Application Ref:	3/2025/0846			 Ribble Valley Borough Council www.ribblevalley.gov.uk				
Date Inspected:	16/12/25	Site Notice:	16/12/25					
Officer:	LW							
DELEGATED ITEM FILE REPORT:					APPROVAL

Development Description:	Replacement of existing garage/ shed with new structure of the same scale and design with minor alterations to external detailing.
Site Address/Location:	Radcliffe Cottage, Goose Lane, Chipping, PR3 2QB.

| CLIENT: | David Custance | REV | DESCRIPTION | DATE | Radcliffe Cottage, Goose Lane Chipping, Preston PR3 2QB Proposed Elevations | | REVISION <div></div> |

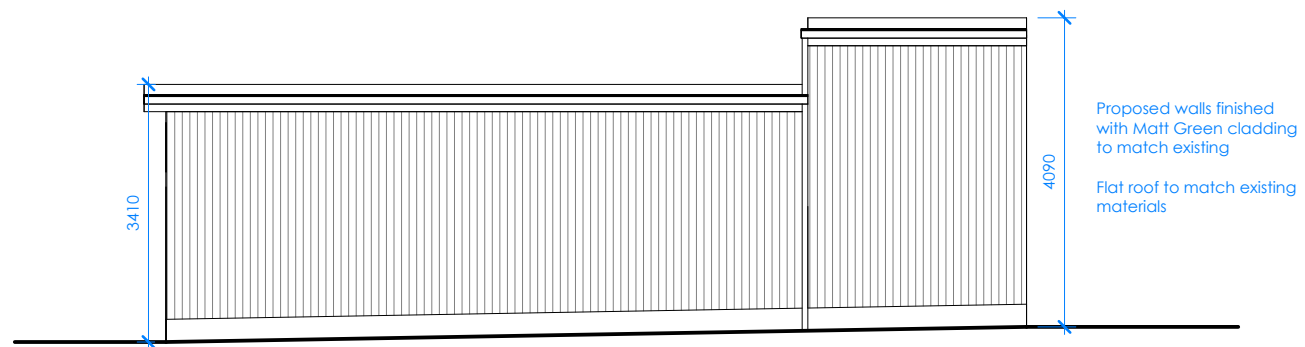
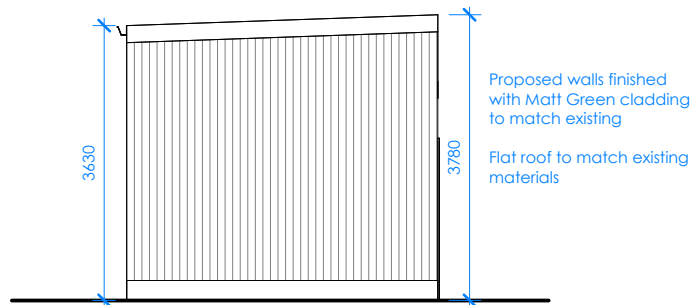
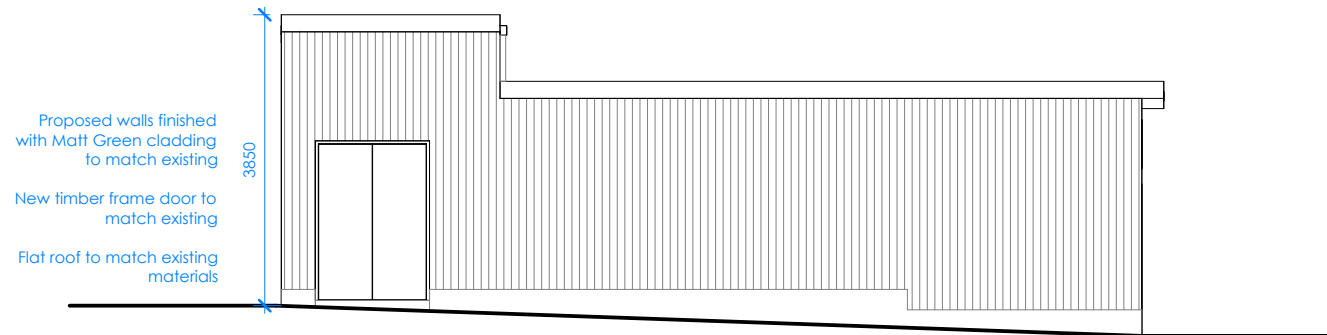
The original scheme proposed a replacement outbuilding with a stepped roof design measuring a maximum of 4.1m in height and constructed from matt green cladding. Whilst it was acknowledged that the development would replace an existing outbuilding of a similar design to that originally proposed, the existing structure is considered industrial in appearance and does not appear wholly sympathetic to the surrounding landscape. As such, the demolition of the existing structure and construction of a new one thus presents an opportunity to achieve a betterment through the construction of a replacement outbuilding that appears more in keeping with the surrounding landscape than that of the existing.

Following discussions with the agent, the original scheme has been amended to incorporate a uniform roof profile measuring a maximum of 3.8m in height, with the originally proposed matt green cladding replaced with timber cladding and a block plinth. The proposal would still comprise a substantial footprint for a domestic outbuilding in a visually prominent location, set forward of the property's principle building line. However, the amended scheme is, on balance, considered an improvement to that of the existing structure and would not result in any greater harm upon the visual amenities of the immediate or wider locality than that of the existing arrangement.
